## Department of Transportation

March 26, 2021

RE: Crossroads at Meadowbrook Mixed Use Preliminary Plan - SH24G/SH94A EPC  
SP2011

EXISTING DRAINAGE MAP
CROSSROADS MIXED USE
JOB NO. 18-003
DATE PREPARED: FEBRUARY 23, 2021
DATE REVISED:

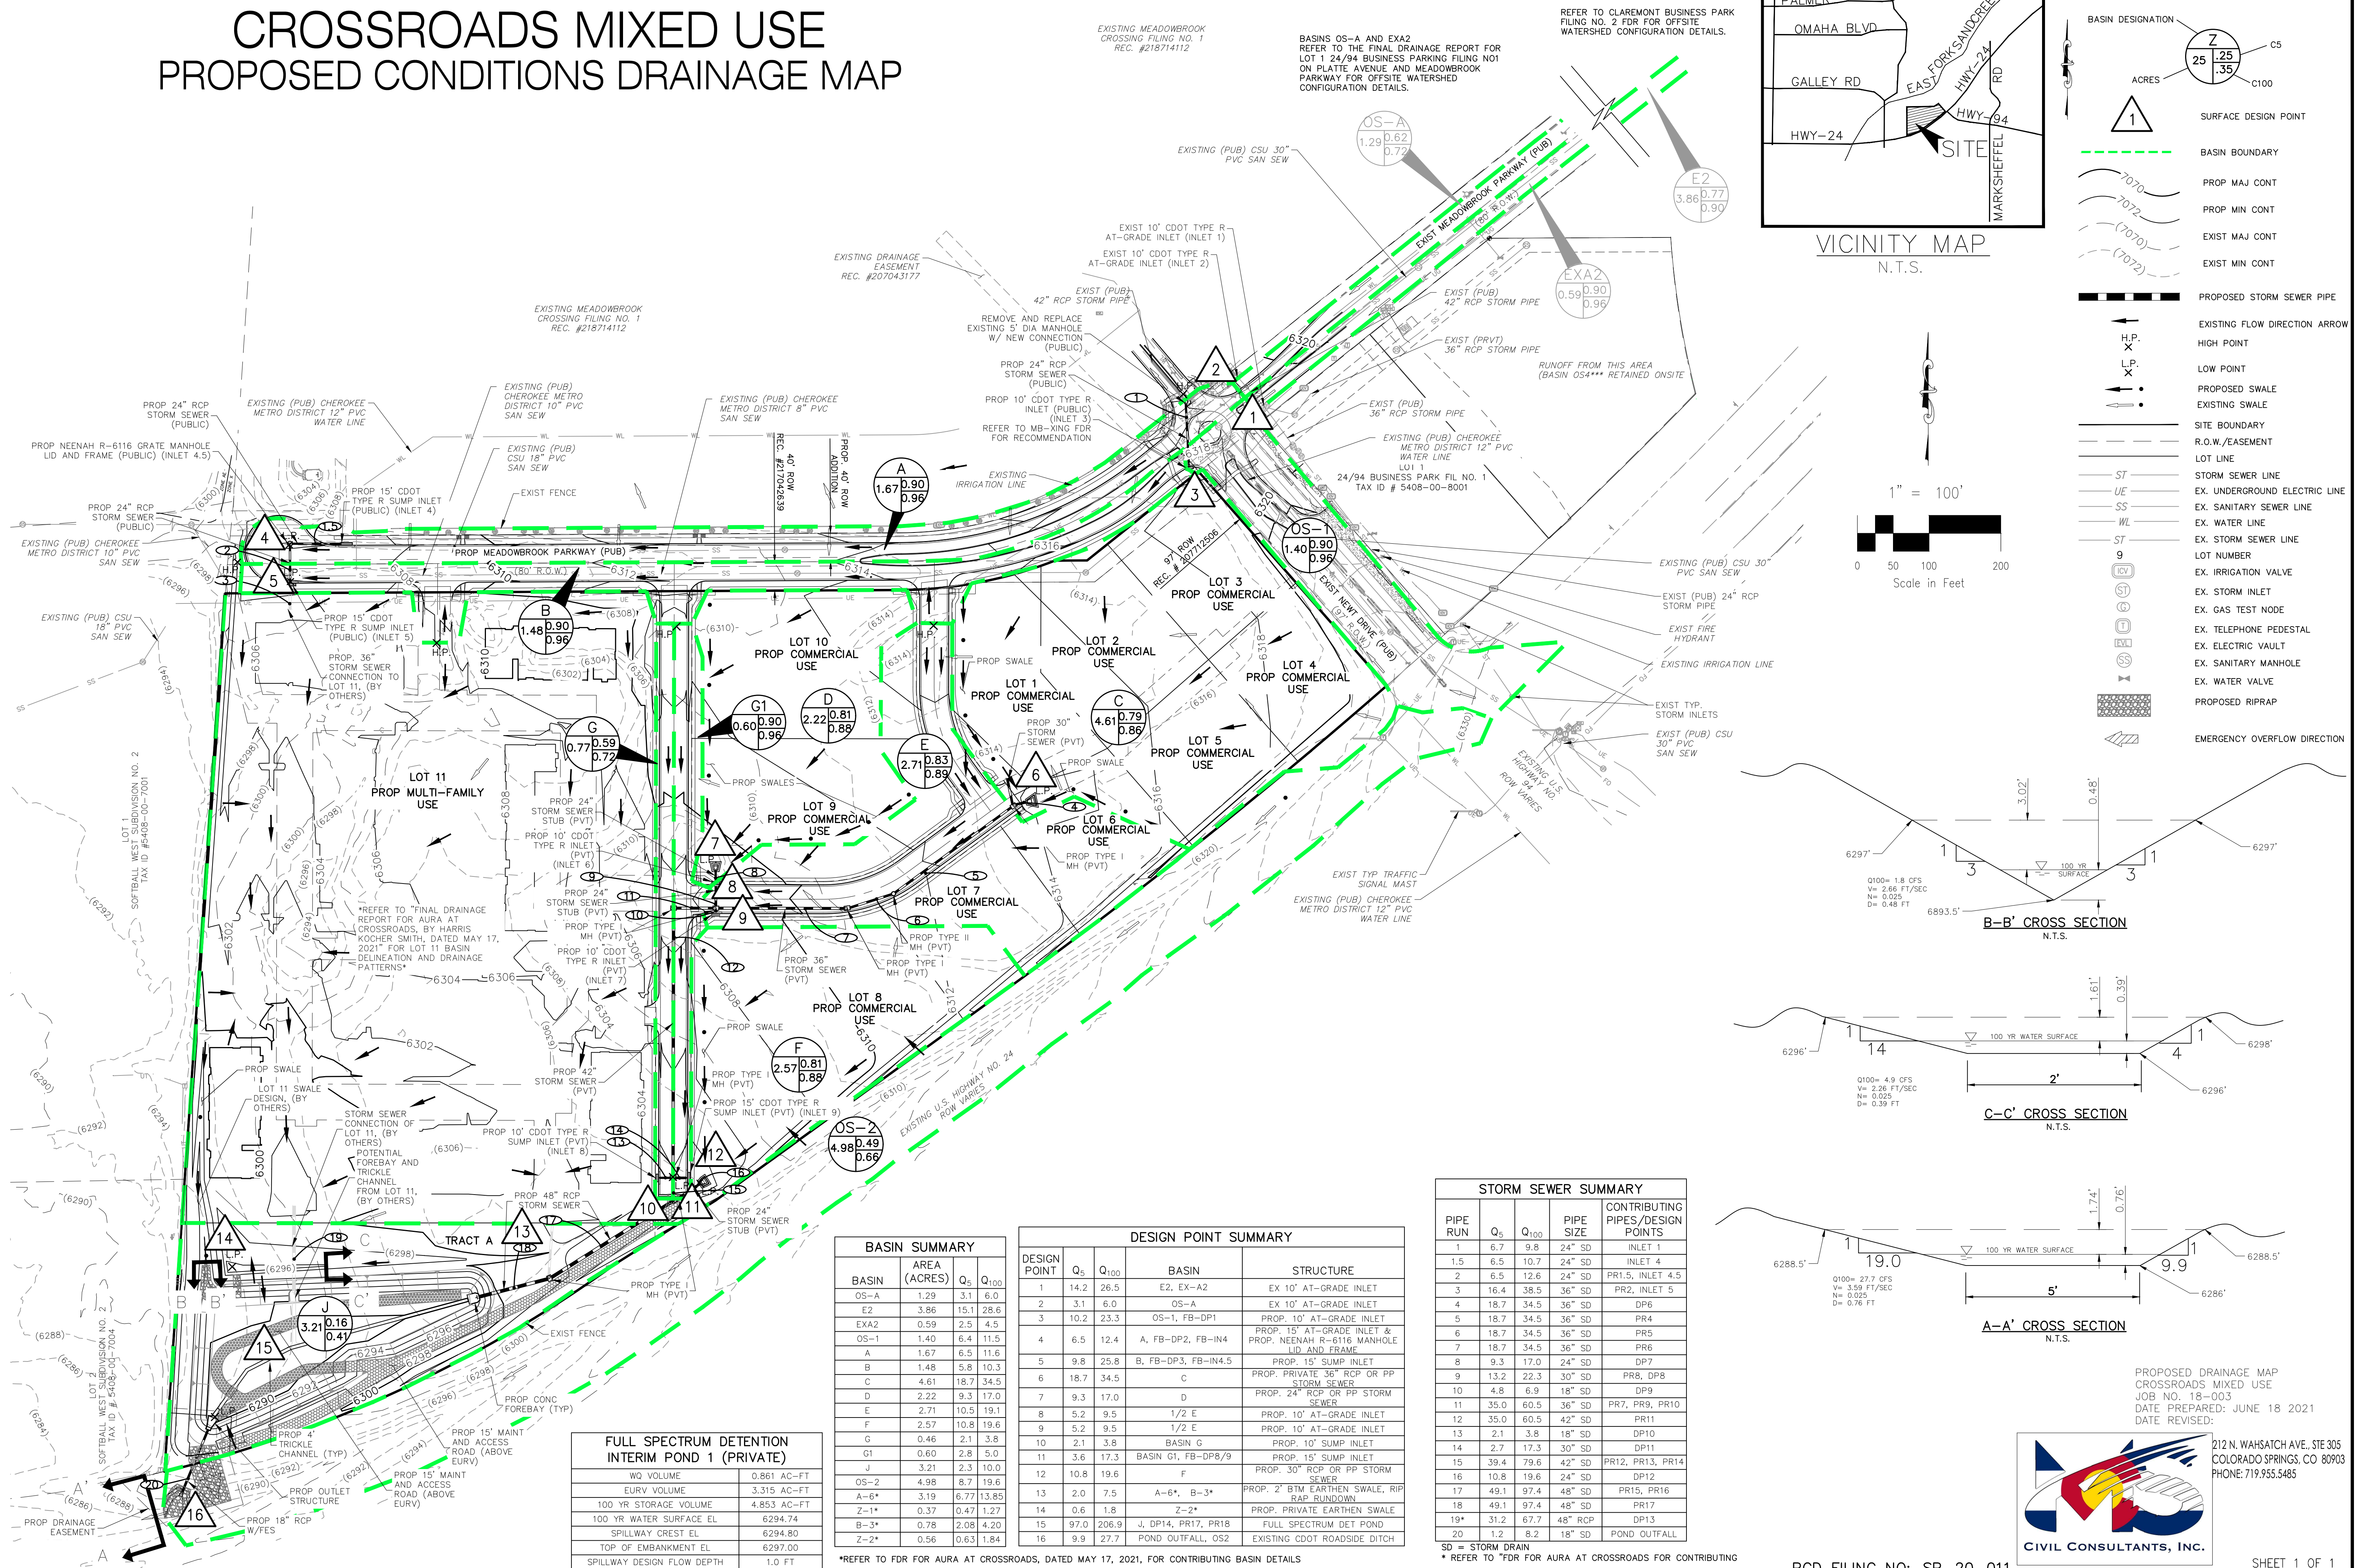
- Existing conditions topo map shows that existing flow at the SW corner sheet flows to the west and that flow does not enter the existing roadside swale. The proposed detention pond outlet concentrates and directs this flow to the roadside swale, which will cause erosion. Please coordinate with CDOT Hydraulics Engineer to design suitable outlet protection.
